**Re: 2025/62/91576/E**

**Erection of detached dwelling; Land Adj, 47 Cresswell Lane, Heckmondwike, WF13 4PJ**

The Coal Authority response: **Clarification Required**

Consultant's Coal Mining Report

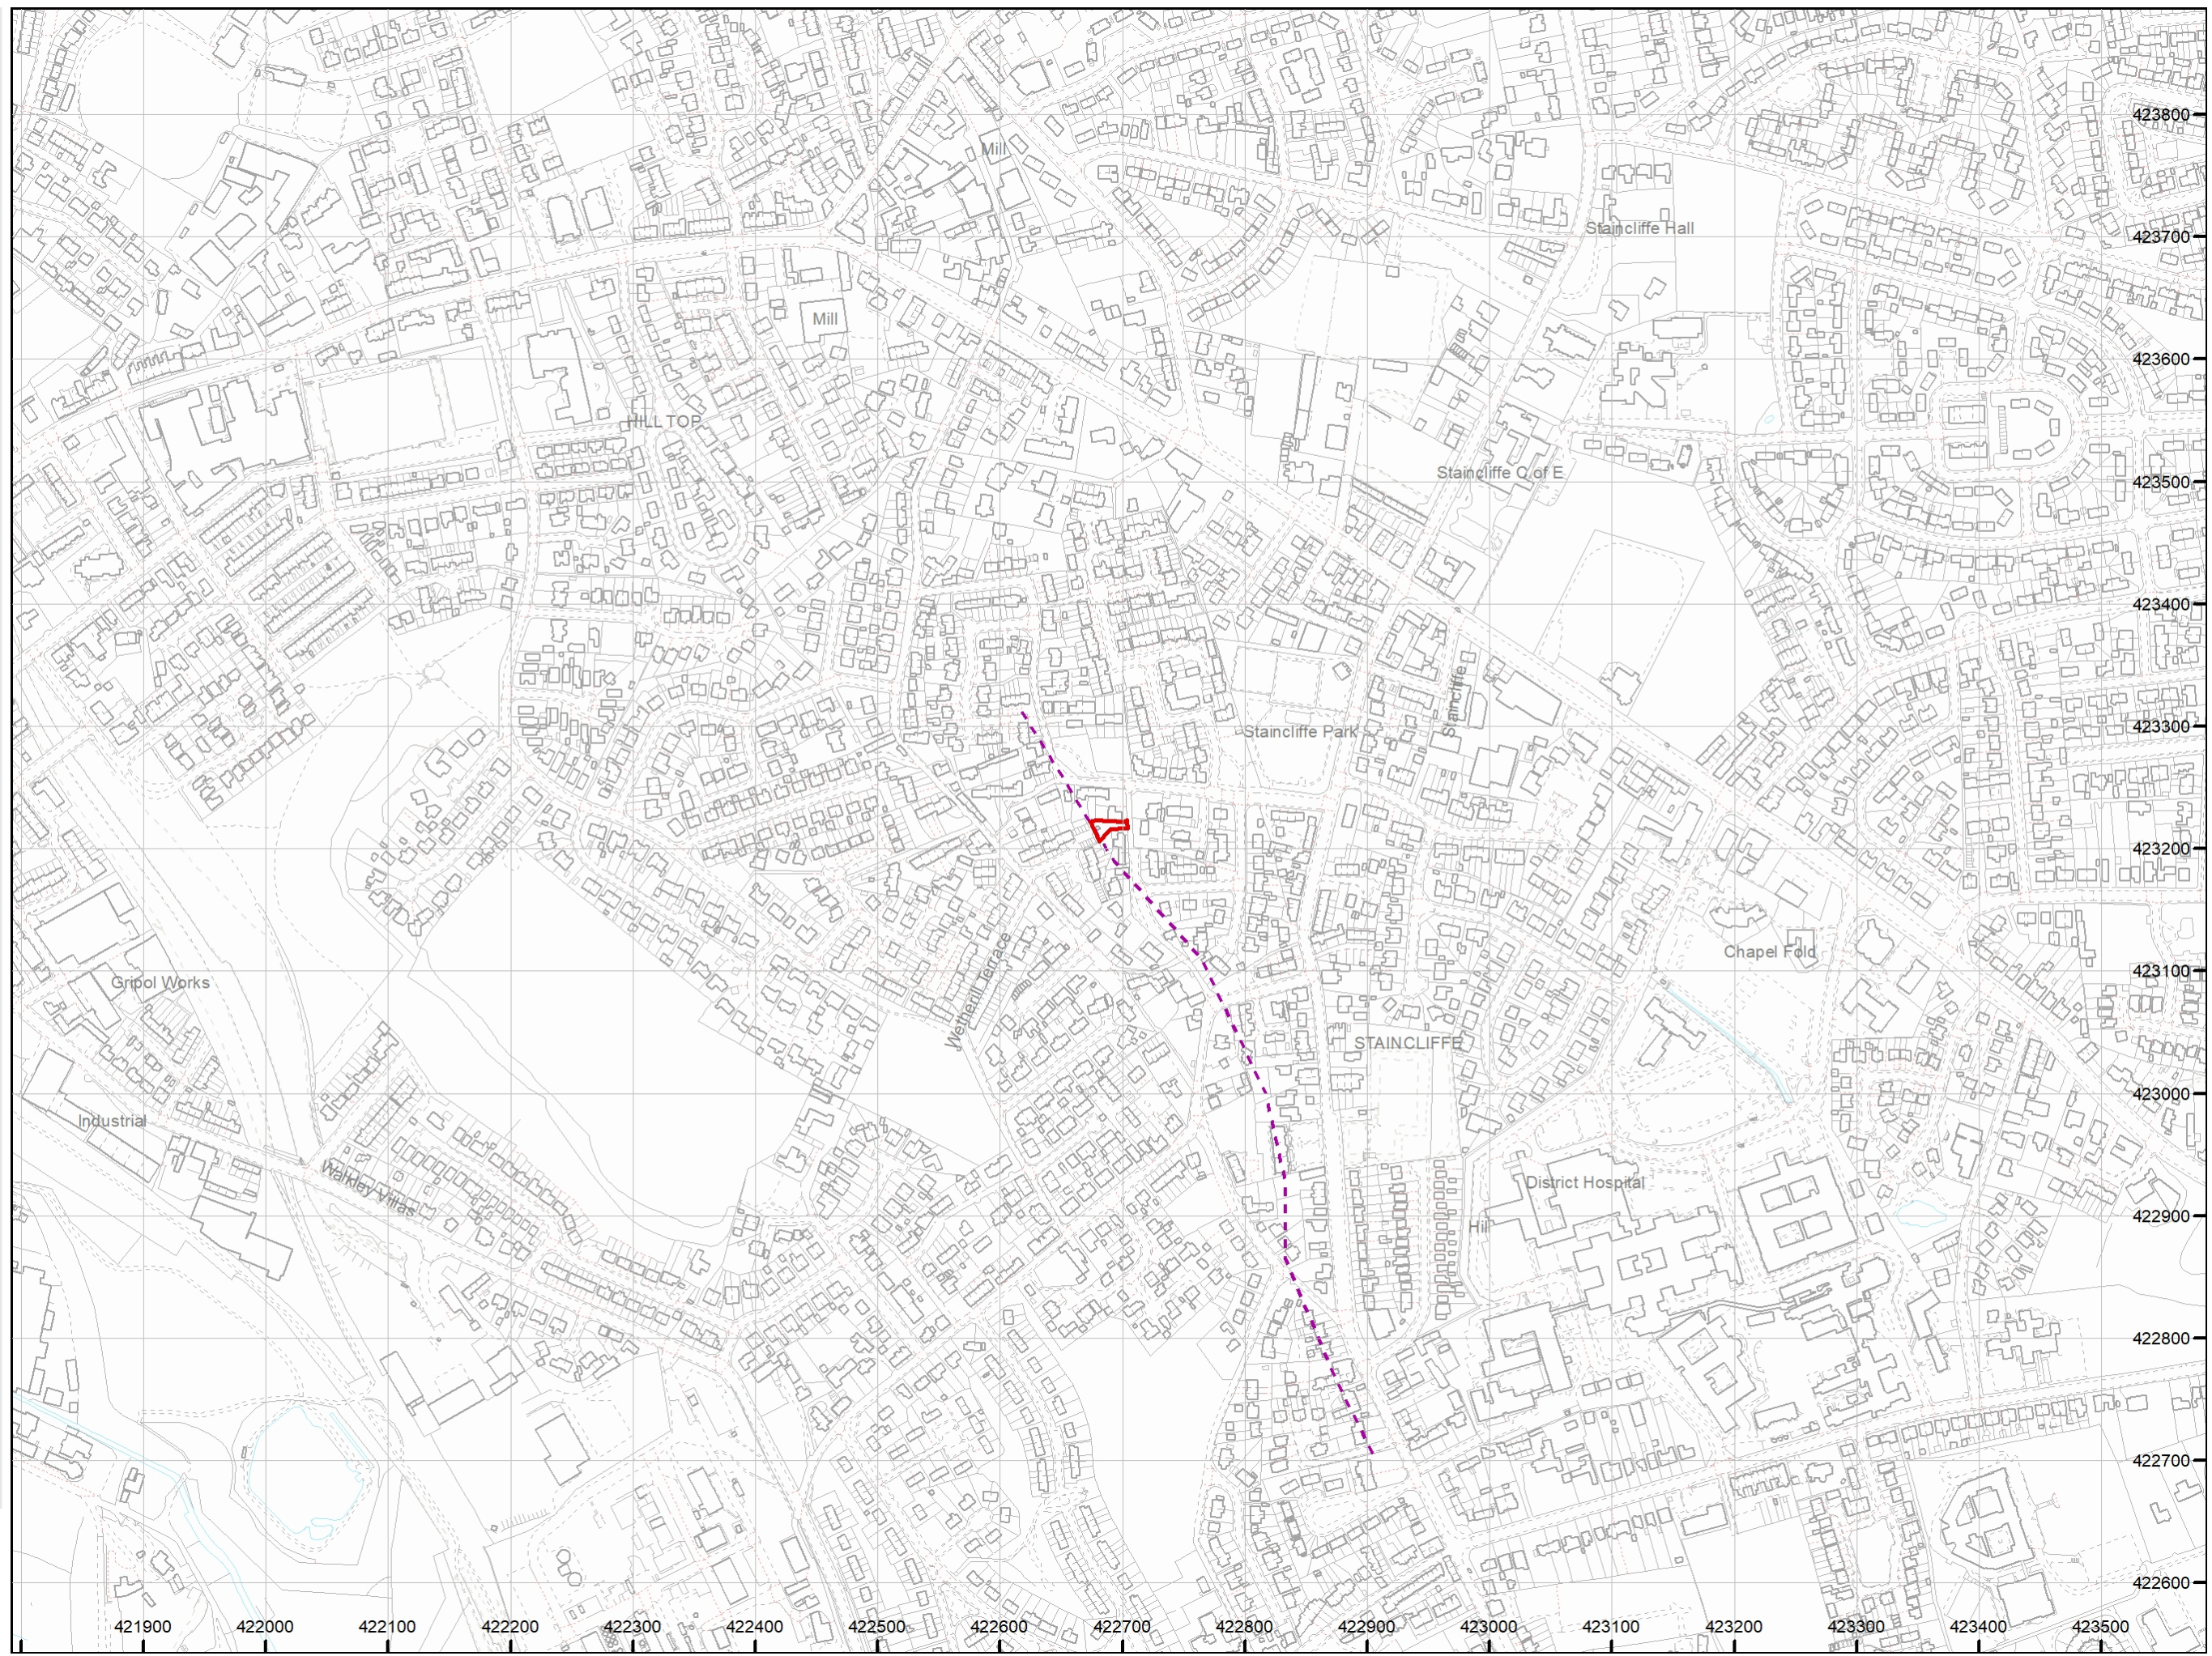
The Coal Authority records indicate that a coal seam (LOW FENTON; also known as 2<sup>nd</sup> Brown Metal Coal) of workable thickness infers to outcrop at or close to the surface of the western part of the site that may have been historically worked from the surface within the site. This could impact on public safety and surface stability for the proposed development.

Having carried out a review of the available information the report author states that a coal seam outcrop (geological mapping) shows the 2<sup>nd</sup> Brown Metal Coal outcropping approximately through the eastern part of the site and based on geological memoirs could result in the Brown Metal Coals being at shallow depth beneath the study site (Section 3.2.4). However the report author goes on to state that as the Mining Remediation Authority states that probable unrecorded shallow workings are determined as 'None' it is unlikely that the Fenton Coal will have been worked. Accordingly the Report concludes that no further investigations or special precautions are required.

We acknowledge that the Consultants Coal Mining Report, 10 July 2025 (part of the evidence used to inform the Assessment) states that 'Probable unrecorded shallow workings = None'. However, as the Report states that the Low Fenton coal seam is of 'workable thickness', we would respectfully ask that the report author confirms that they remain satisfied that there is no risk to the proposed development from shallow coal workings in the Low Fenton seam and no mitigation measures are considered necessary.

Subject to the submission of the above (underlined text) the Planning team at the Coal Authority would have no objection to the proposed development. This would be subject to the LPA adding the following wording to the Decision Notice:
